Application for a non-material amendment following a grant of planning permission.

<input type="text" value="Change of use from entertainment and leisure (Use Class D2) to teaching facility (Use Class D1)"/>	
Reference number:	<input type="text" value="6/2019/1338/FULL"/>
Date of decision	<input type="text" value="20/08/2019"/>

Installation of fascia panel along perimeter of roof on north and east elevations

DRAWING TITLE
**SPORTS SCIENCE BUILDING
PROPOSED EAST ELEVATION**

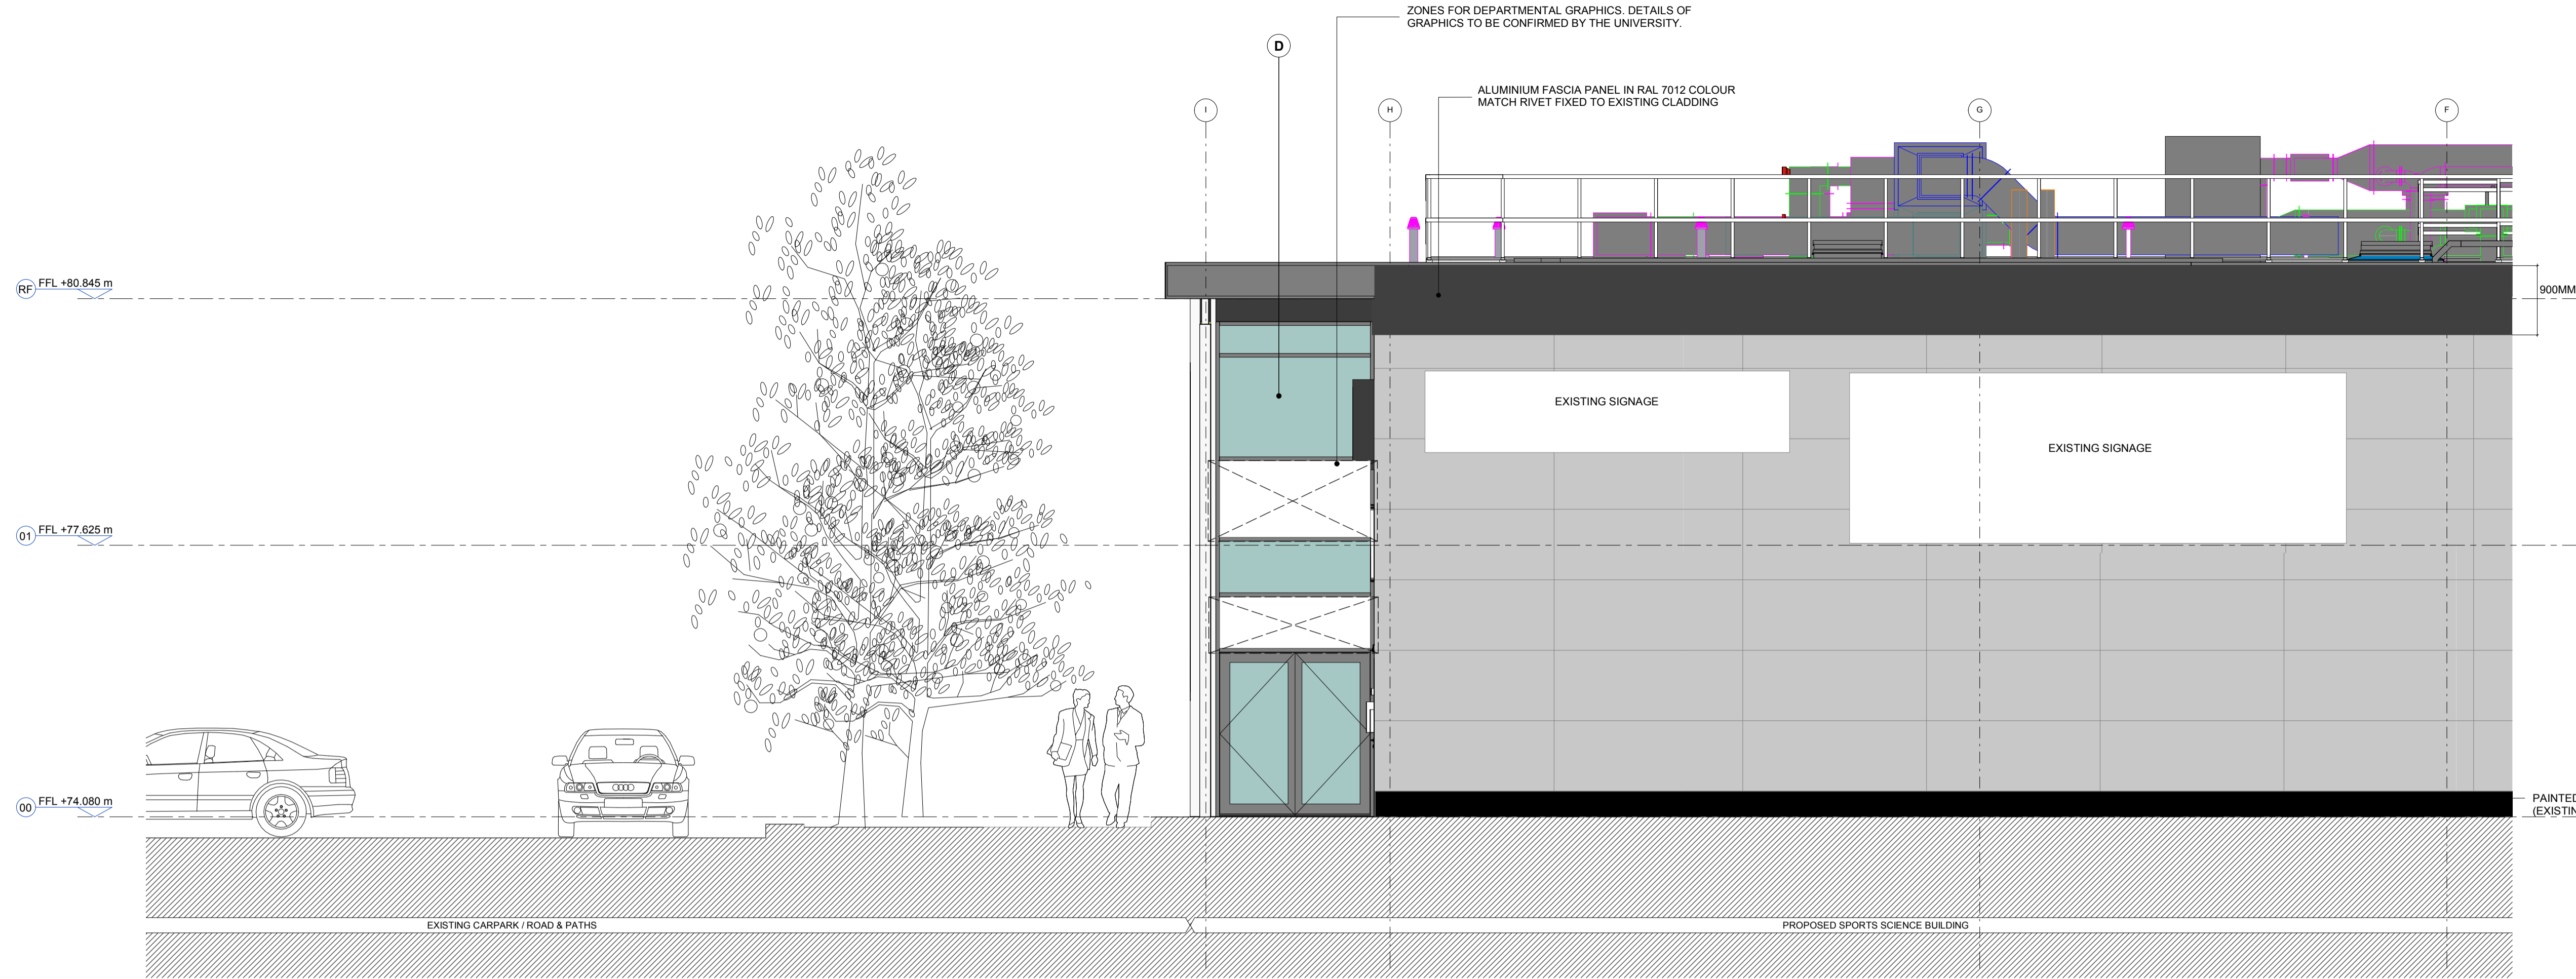
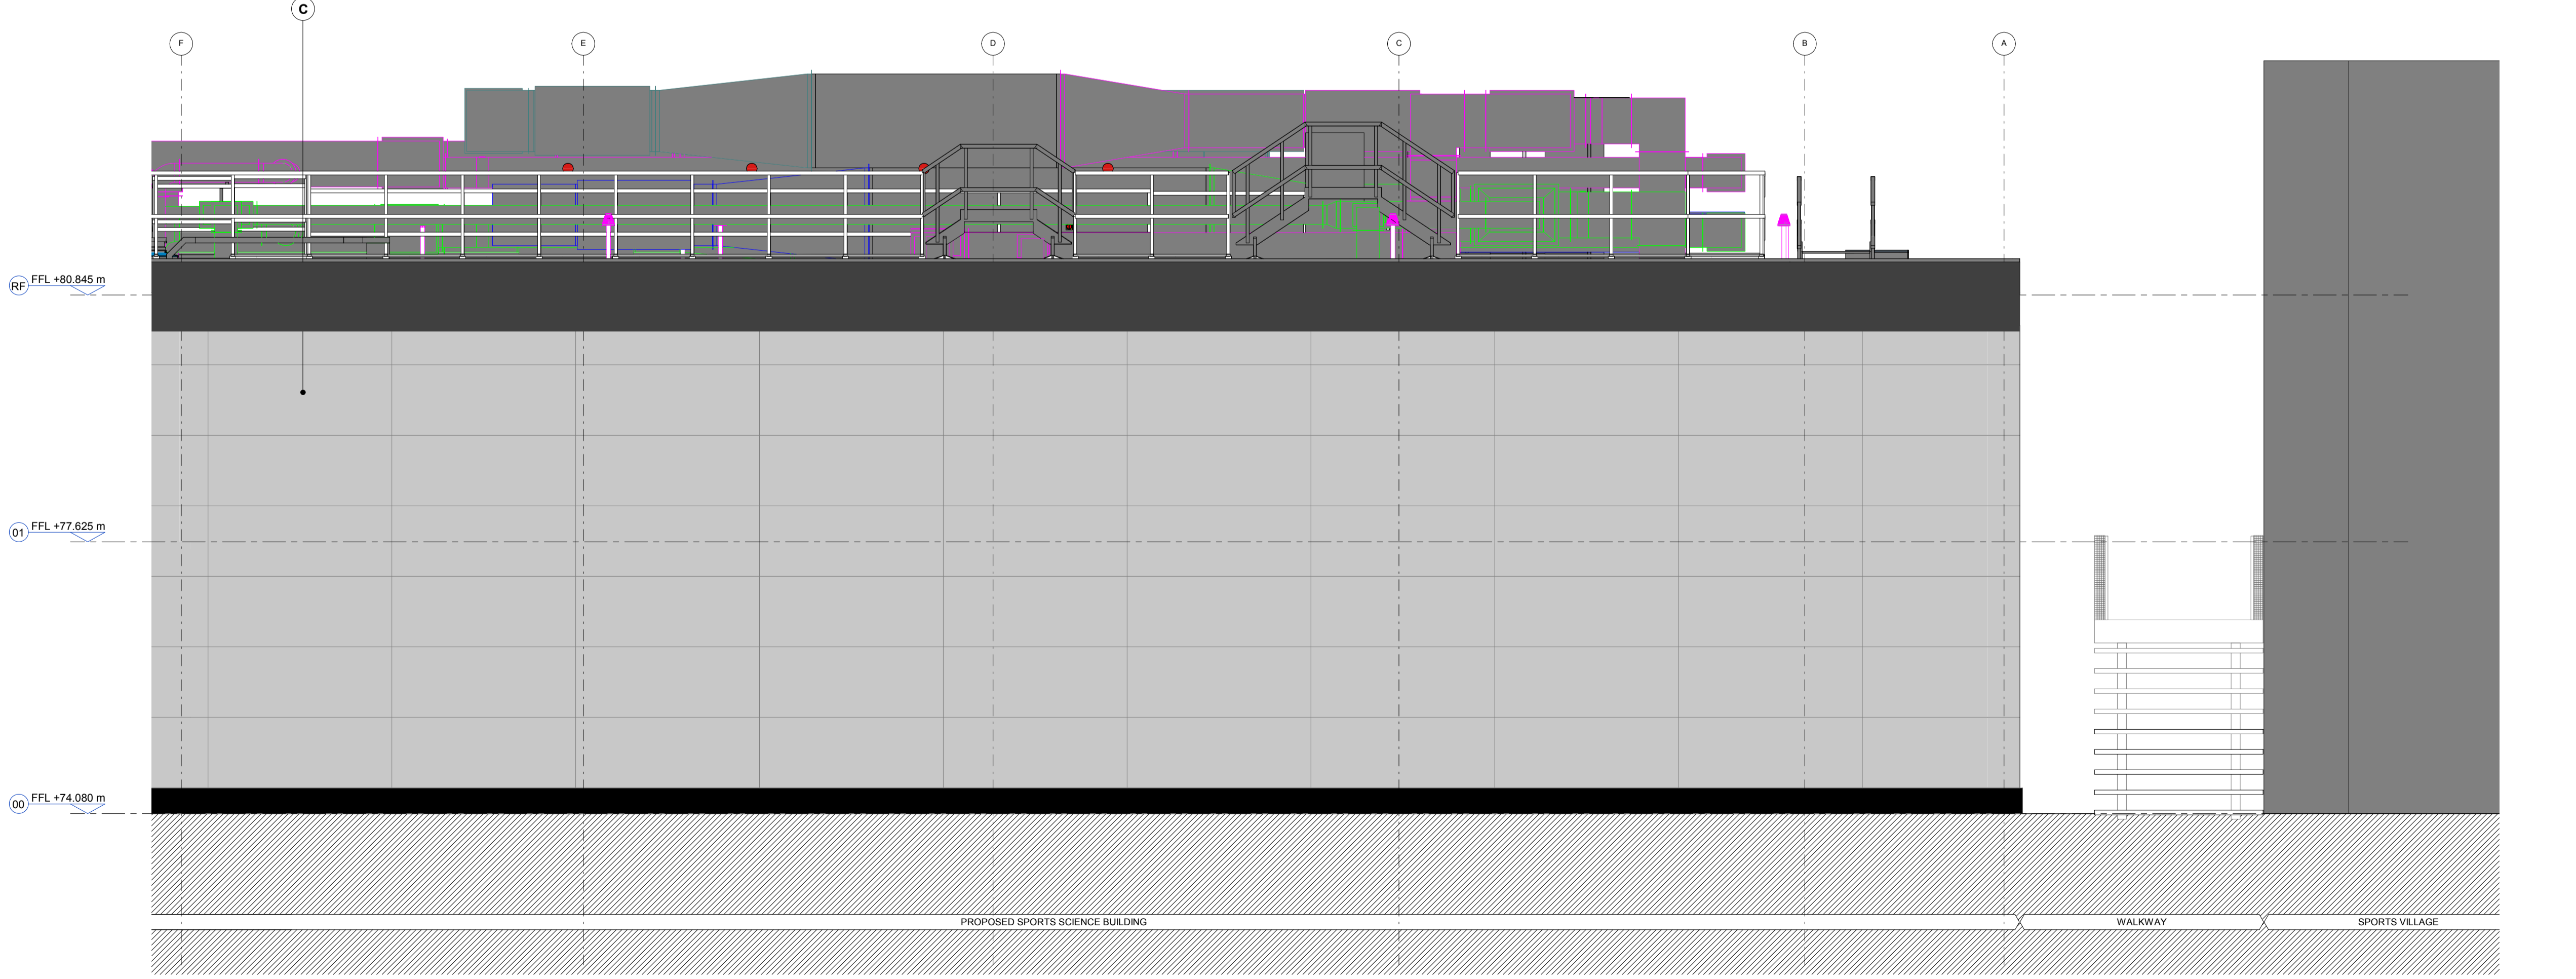
During the construction process several leak points were found around the perimeter of the existing roof. In order to resolve this our client has had to dress the new roof membrane into a new fascia panel which runs the perimeter of the roof along the north and east elevations.
